Charlotte Department of Transportation

Memorandum

Date: January 25, 2008

Subject: Rezoning Petition 08-039: Located on the southeast corner of Providence Road and Alexander Road

Scale:	1" = 30'
Date:	7 NOV 2007
Project No.:	263-001
Revisions:	1. 2-18-08 PER CMPC COMMENTS
Sheet	L-1

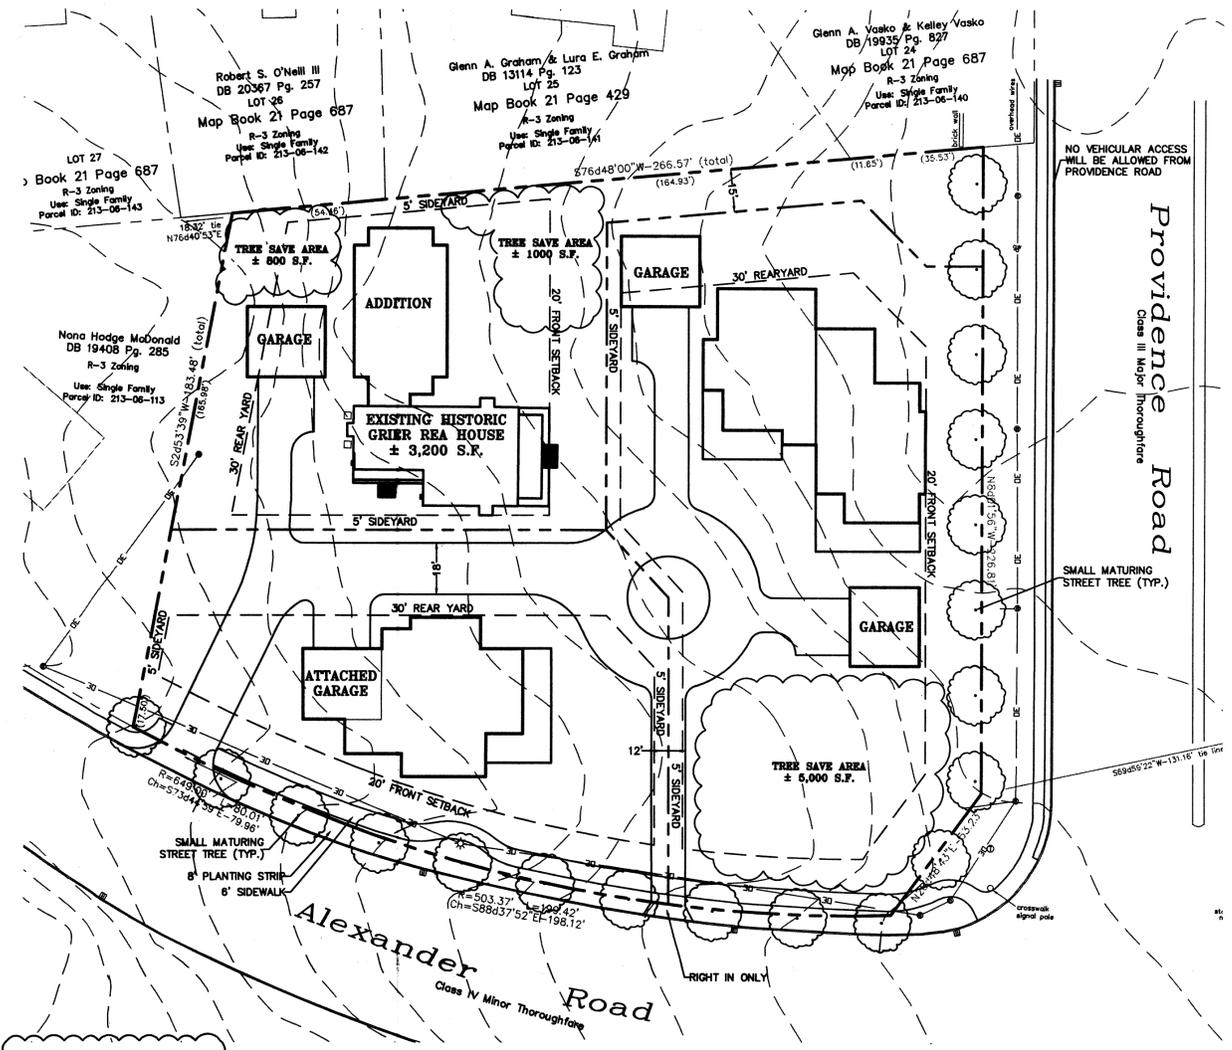
1. The petitioner needs to replace existing sub-standard sidewalks along Alexander and Providence Roads with 6-foot sidewalks and 8-foot planting strips, as well as directional ramps (two per corner) at the intersection of Alexander and Providence Roads.
2. The petitioner needs to eliminate the driveway closest to Providence Road, retaining only one driveway on Alexander Road. This driveway needs to be as close to the east property line as possible.

3. The Development Conditions need to include a note prohibiting access to Providence Road. CDOT and the NCDOT will not permit driveway access onto Providence Road for this site.

Adequate sight triangles must be reserved at the proposed street entrances. Two 35' x 35' sight triangles are required for the entrance to meet requirements. All proposed trees, berms, walls, fences, and/or identification signs must not interfere with sight distance at the entrance. Such items should be identified on the site plan.

The proposed driveway connection to Alexander Road will require a driveway permit to be submitted to CDOT for review and approval. The exact driveway locations and type/width of the driveways will be determined by CDOT during the driveway permit process. The location of the driveway shown on the site plan is subject to change in order to comply with City Driveway Regulations and the City Tree Ordinance.

- Dimension width of the existing and proposed driveways.
- New/reconstructed driveways must be drop curb ramp Type II-Modified driveways.
- Indicate the locations and widths of all adjacent and opposing driveways.
- Directional wheelchair ramps (two per corner) should be provided at all intersections of public and private streets.
